**Addendum No. 2**

RE: Contract # C204271

**Onslow County**

1 Section of US-17 And 25 Sections of Secondary Roads

TYPICAL SECTION NO. 1

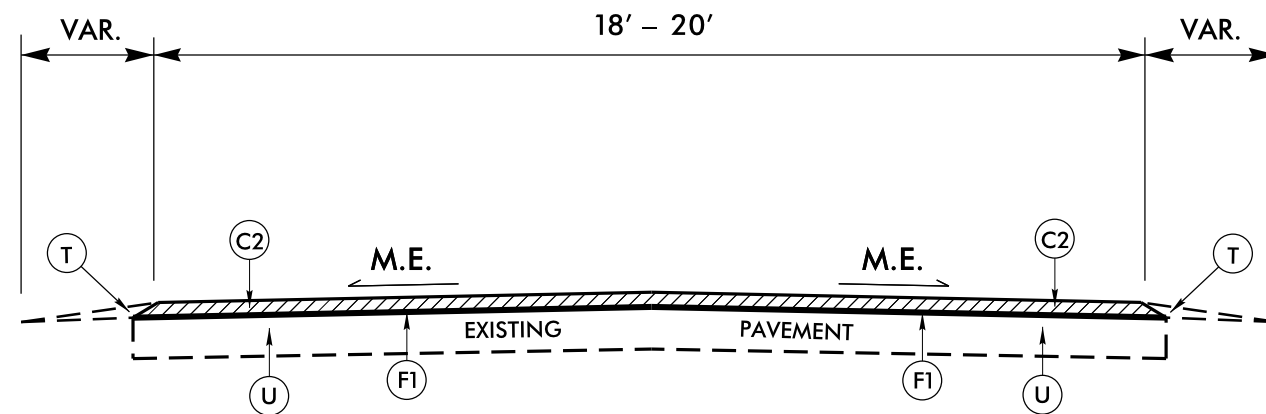
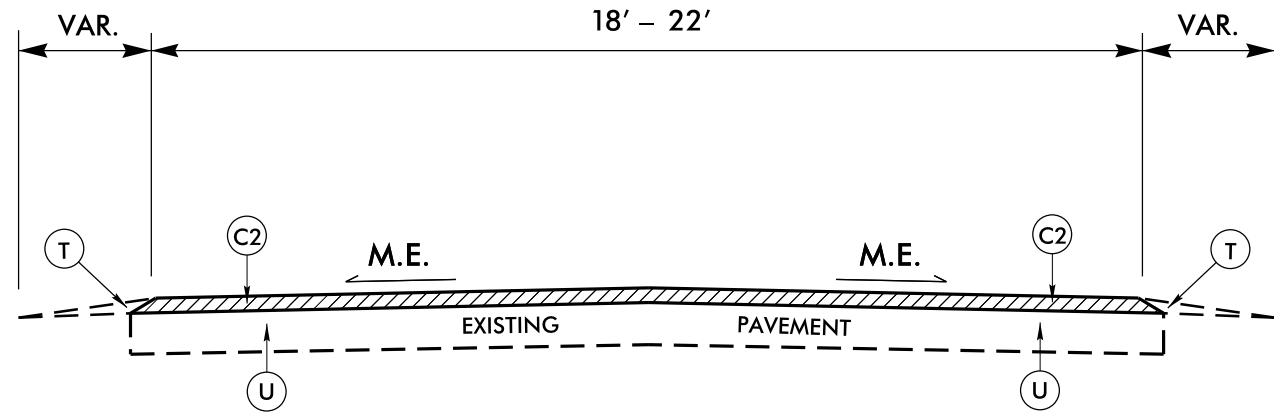
| Sheet No. | Revisions   |
|-----------|---|
| 4         | The second note under Typical Section No. 1 was revised, under Typical No. 2 the description for "V2" was revised and a second note was added |
